Application no: 22/03397/DISC

Location: Land To The South And Adj To, South Side, Steeple Aston

Lead Local Flood Authority

Objection

Client	rectory
Project	South Side Steeple Aston
Scale:	1:200 @ A1
Status:	PRELIMINARY
Drawn:	Project Engineer
Checked:	RF
Project No:	6374
Date:	14/05/2021
Drawing Number:	6374-MJA-SW-XX-DR-C-200
Rev:	P4

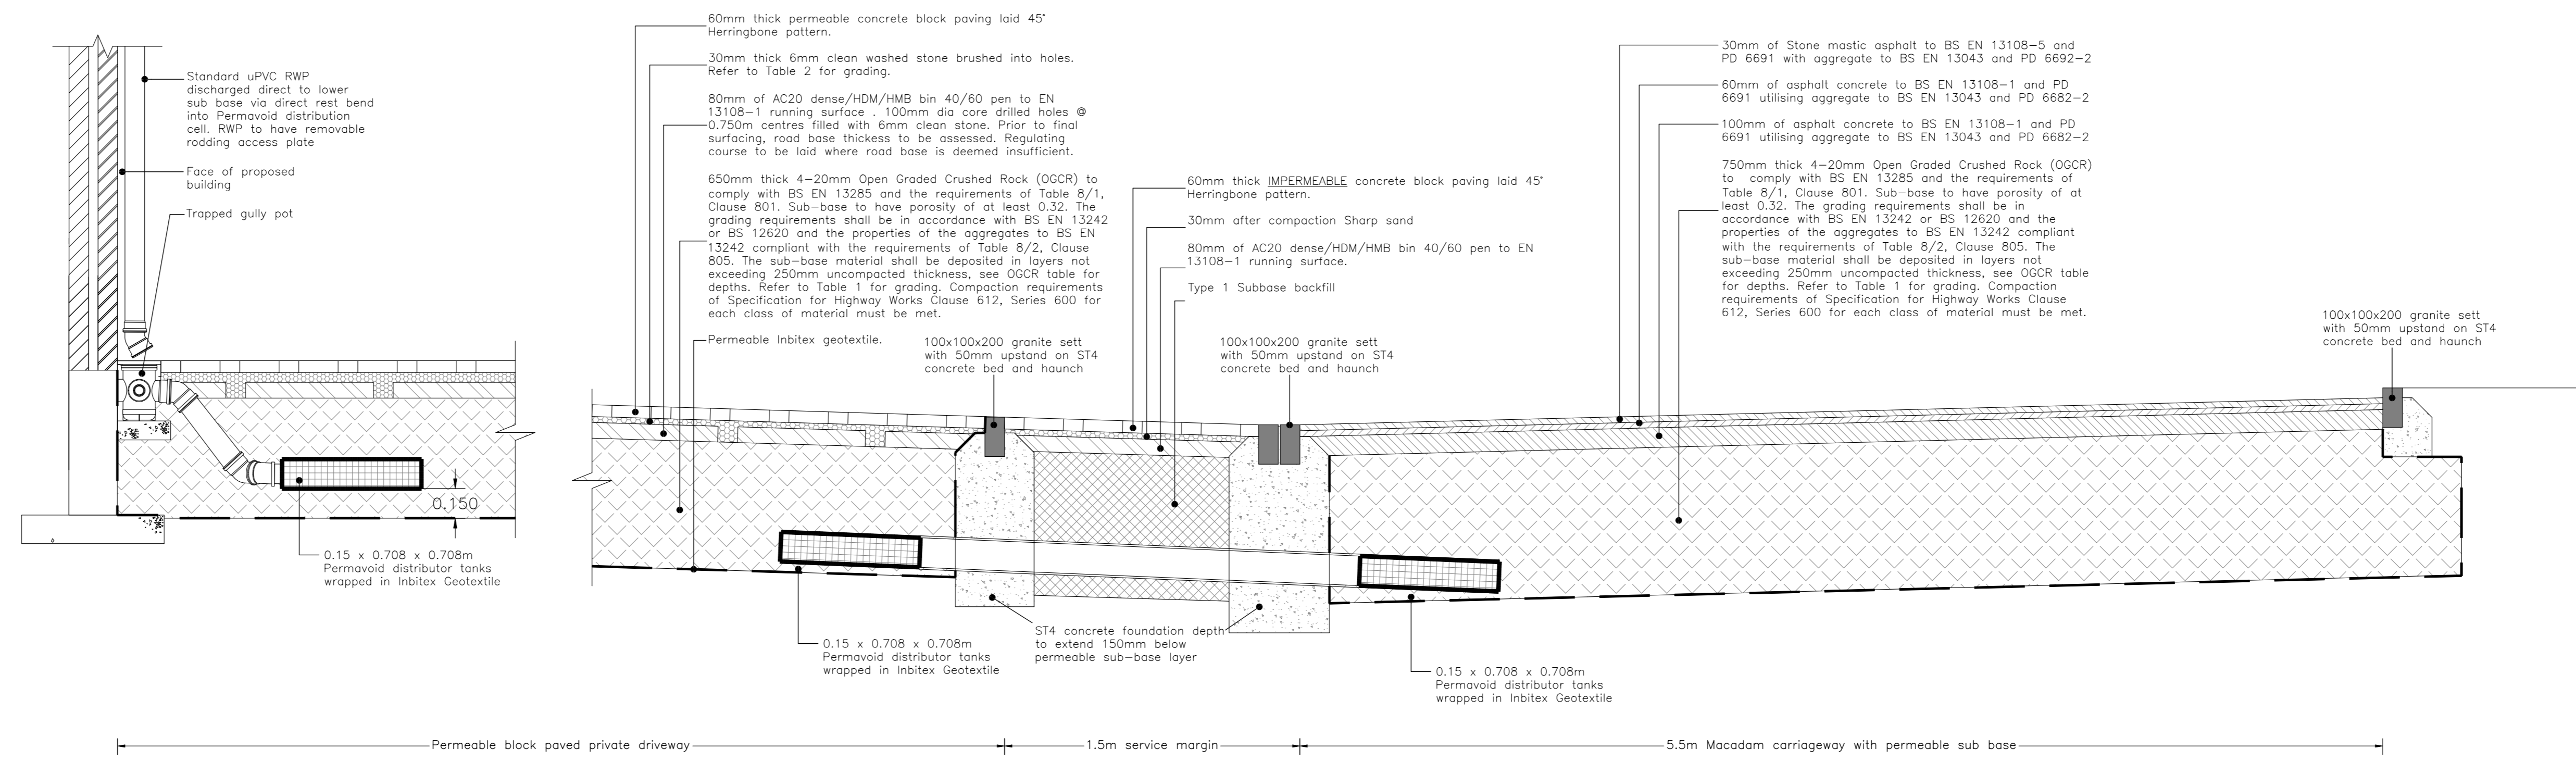
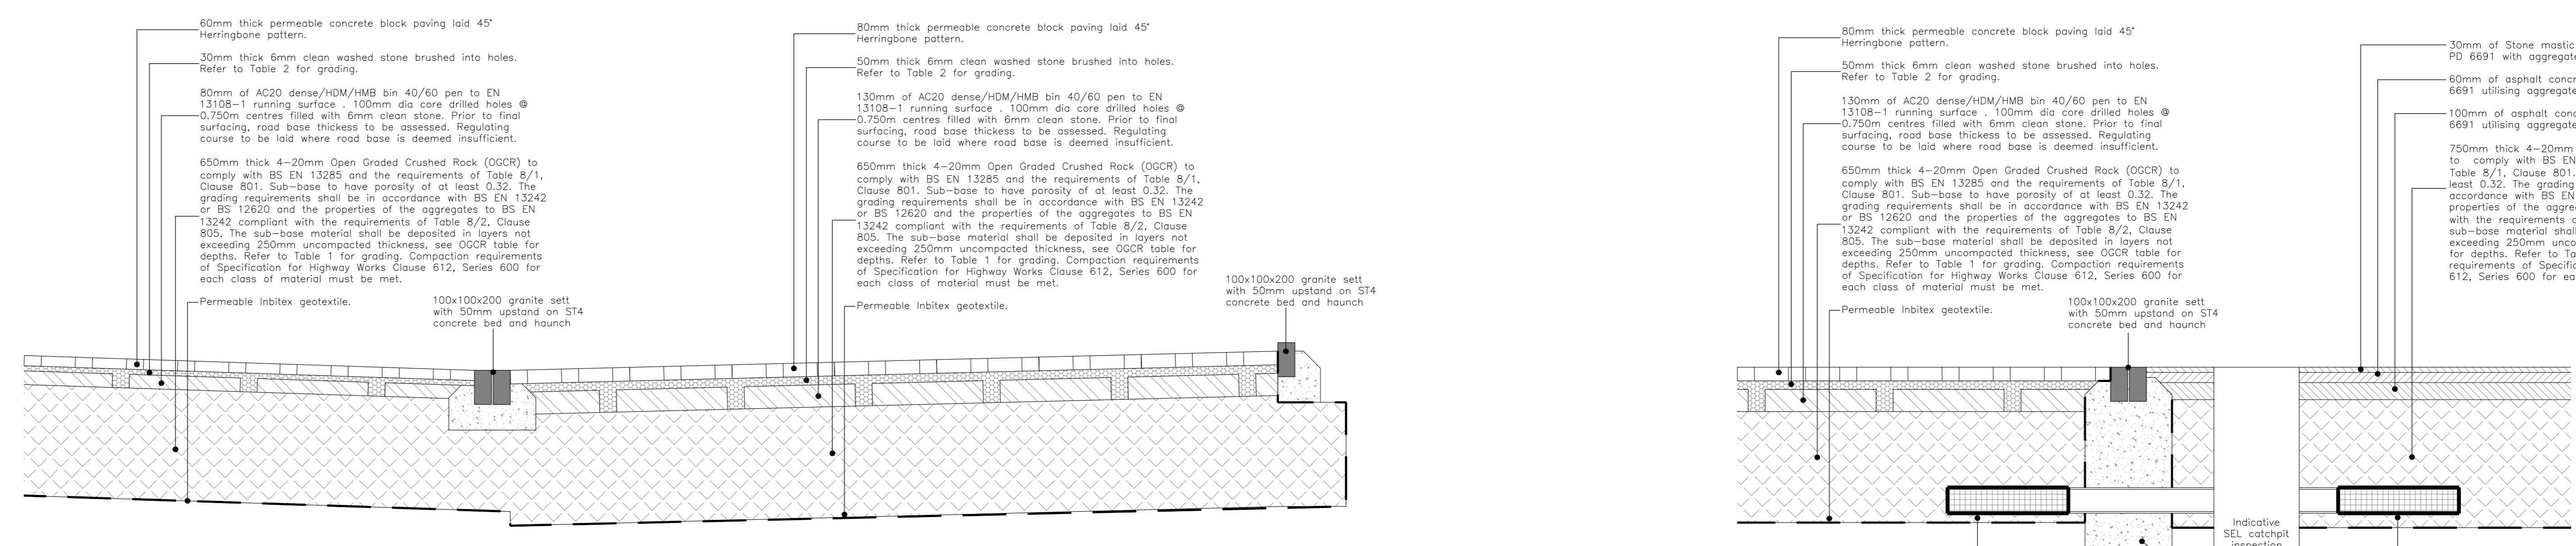
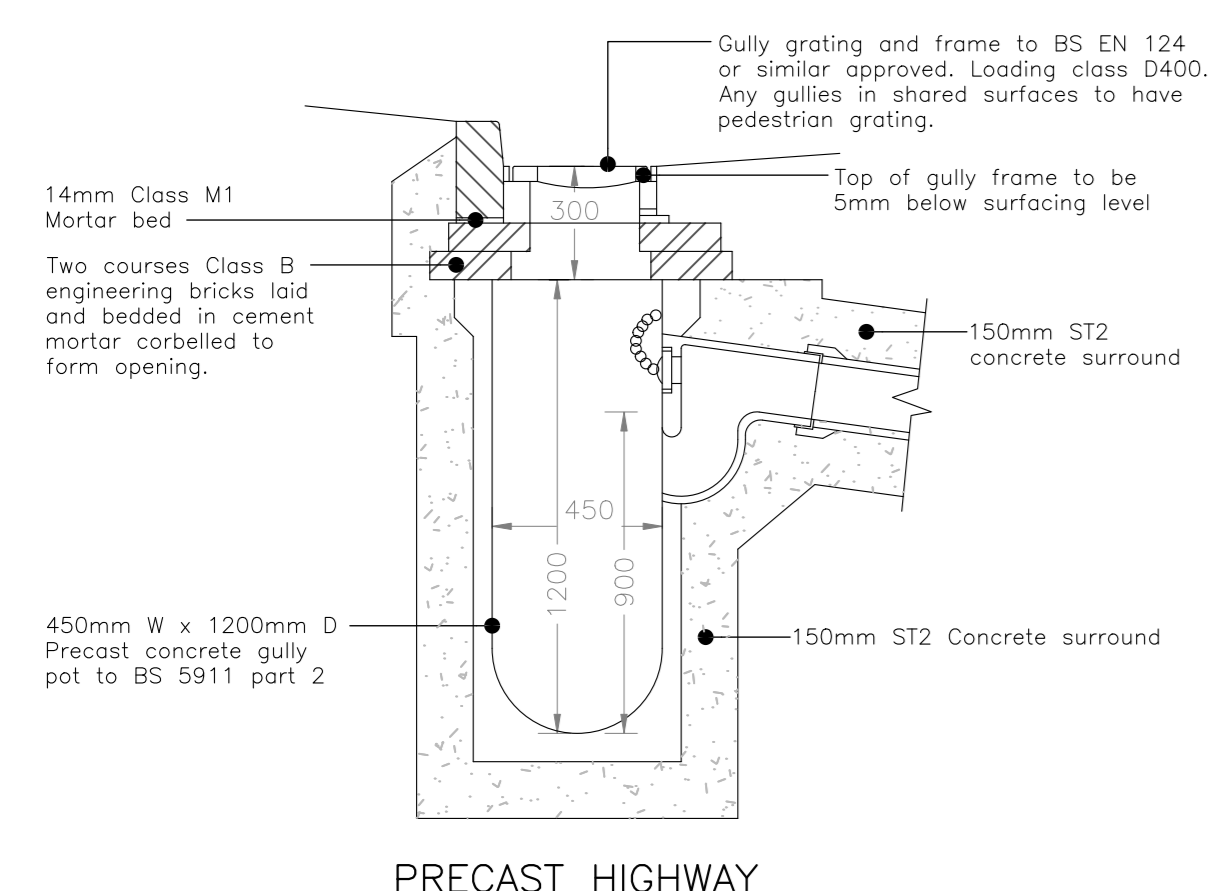
Not provided. The drainage strategy drawing provided is REV P4 which does not state to be an as built drawing. As built drawings needs to be clearly referenced on plan.
